CITY OF ALBUQUERQUE

March 19, 2020

Re: ABQ RV & Storage
2210 Vista Oriente NW, 87120
30-Day Temporary Certificate of Occupancy
Transportation Development Final Inspection
Engineer's/Architect's Stamp dated 5-1-19 (AA) (H10D006B)
Certification dated 3-13-20

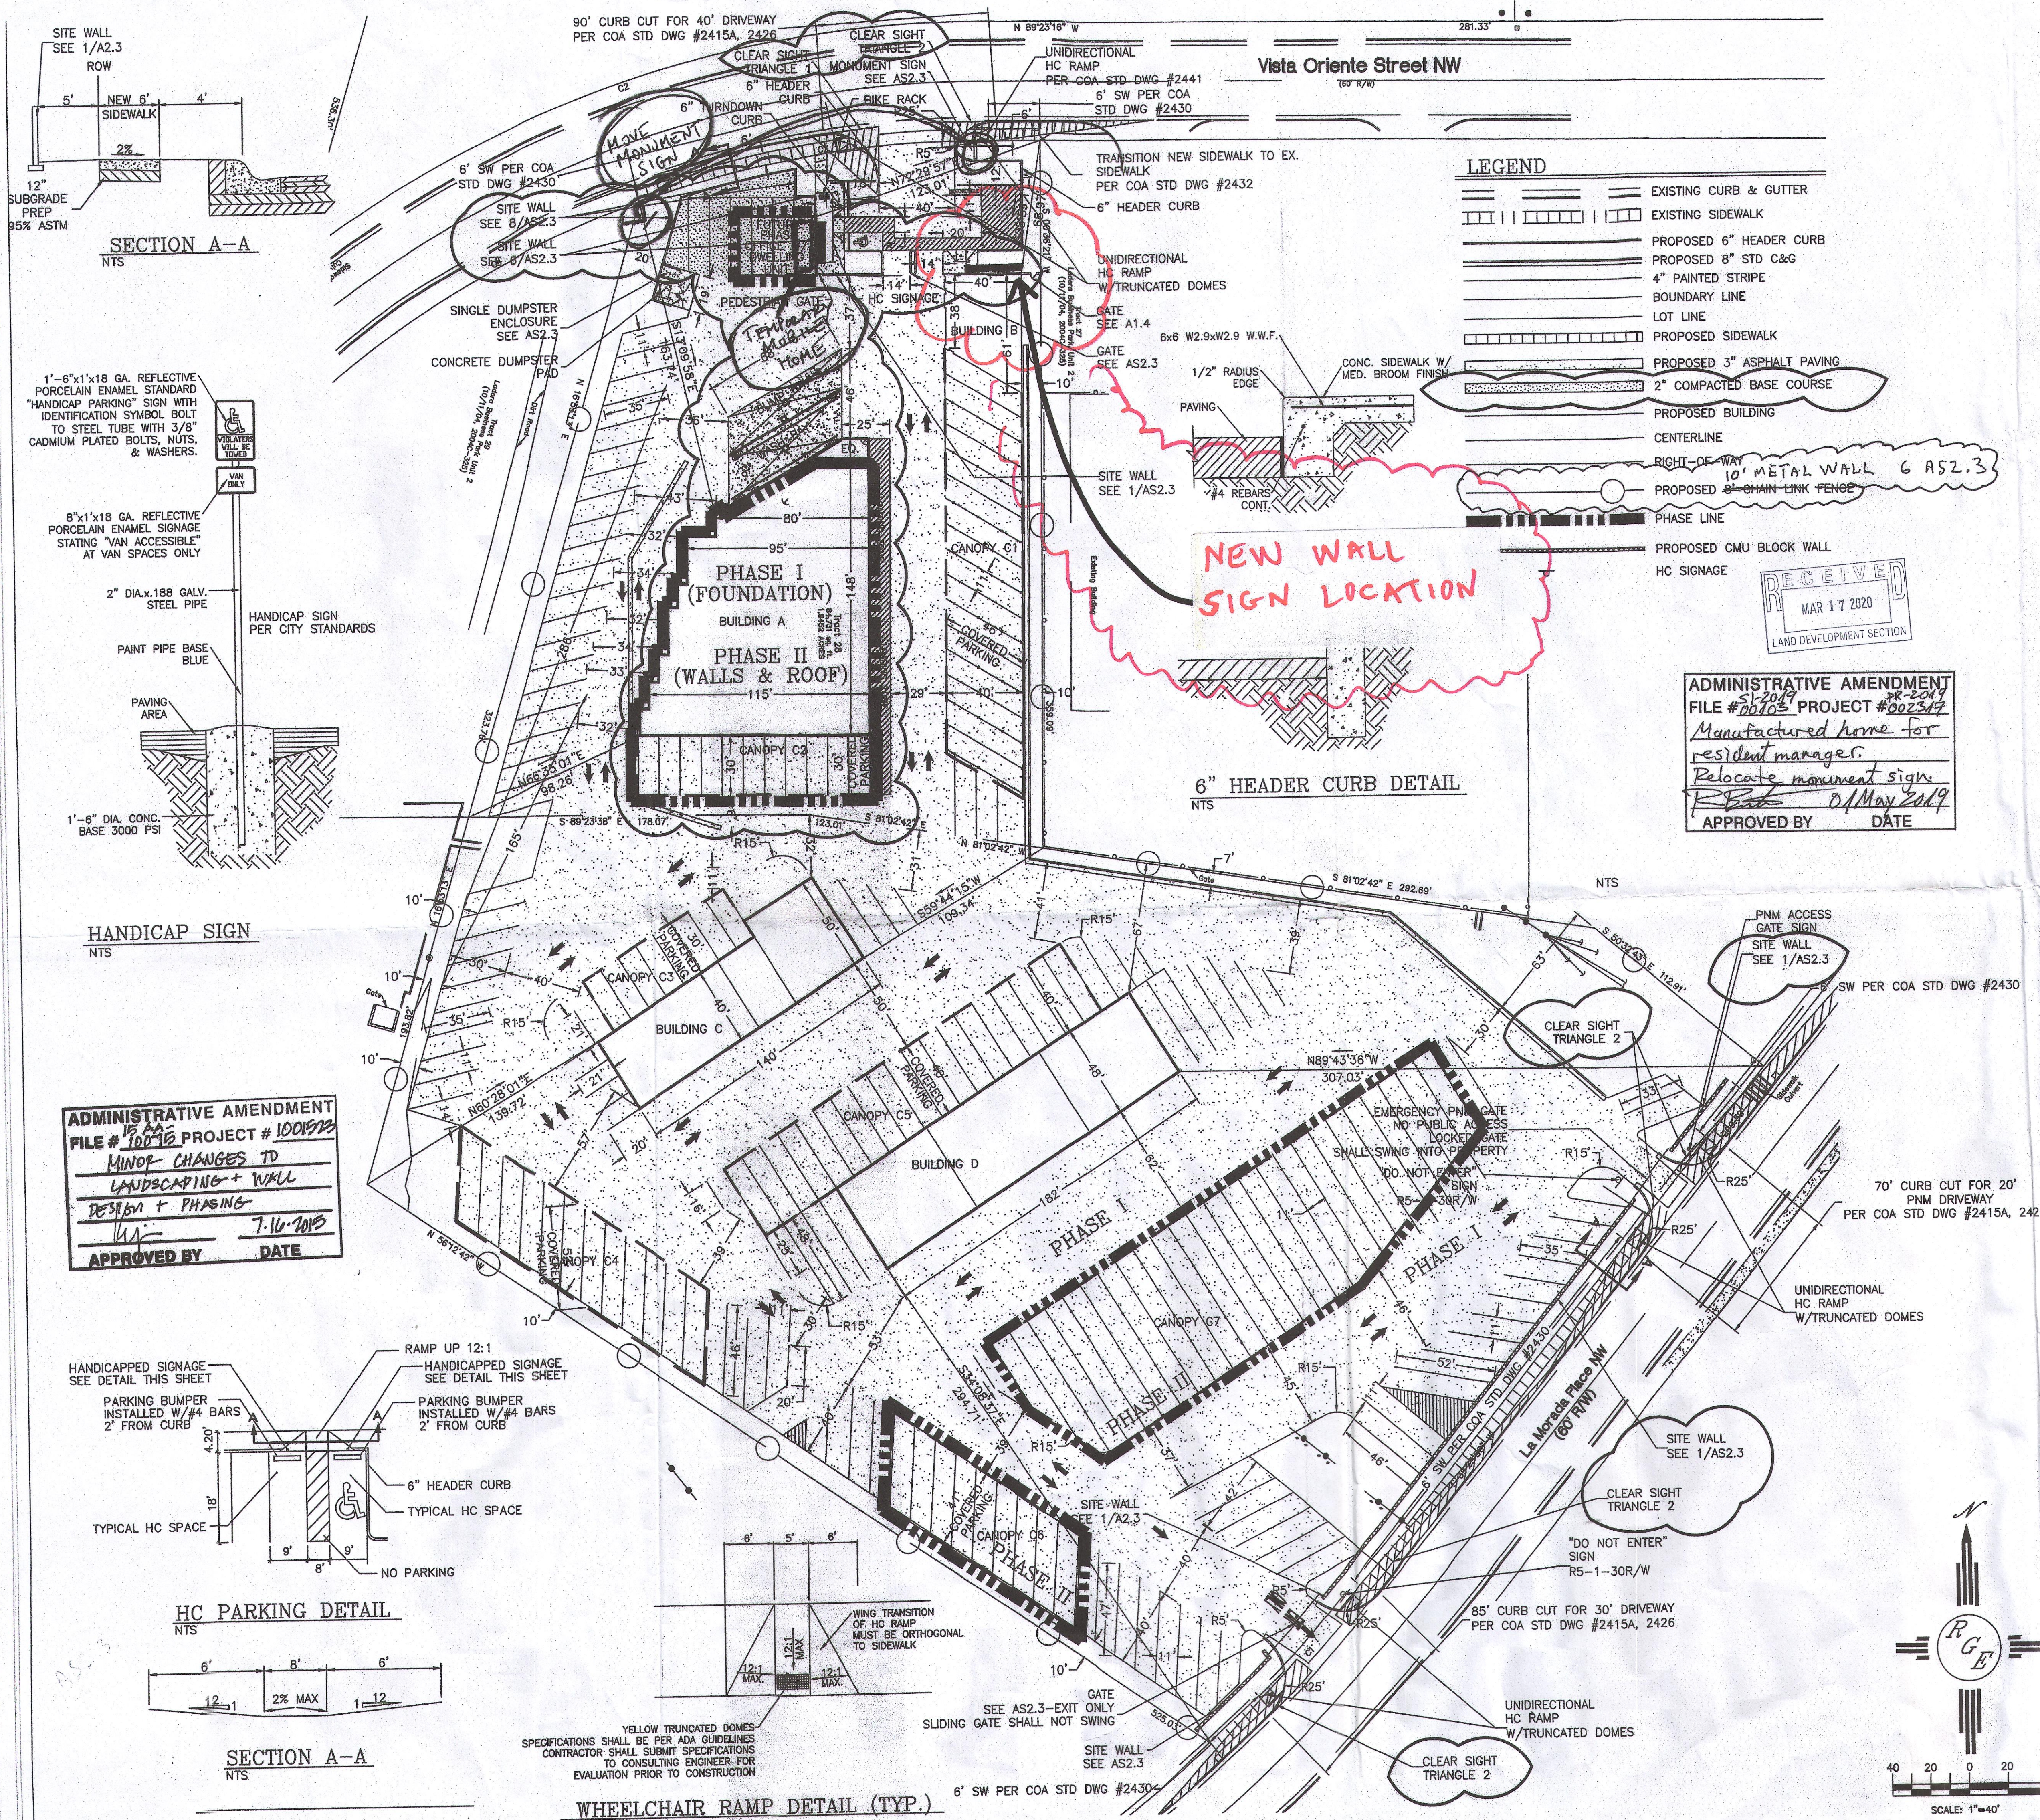
1. Please add Motorcycle Sign. Motorcycle parking spaces shall be designated by its own conspicuously posted upright sign, either free-standing or wall mounted per the IDO.
2. Please add ADA signs. The ADA accessible parking sign must have the required language per 66-7-352.4C NMSA 1978 **"Violators Are Subject to a Fine and/or Towing."** Please call out detail and location of signs.
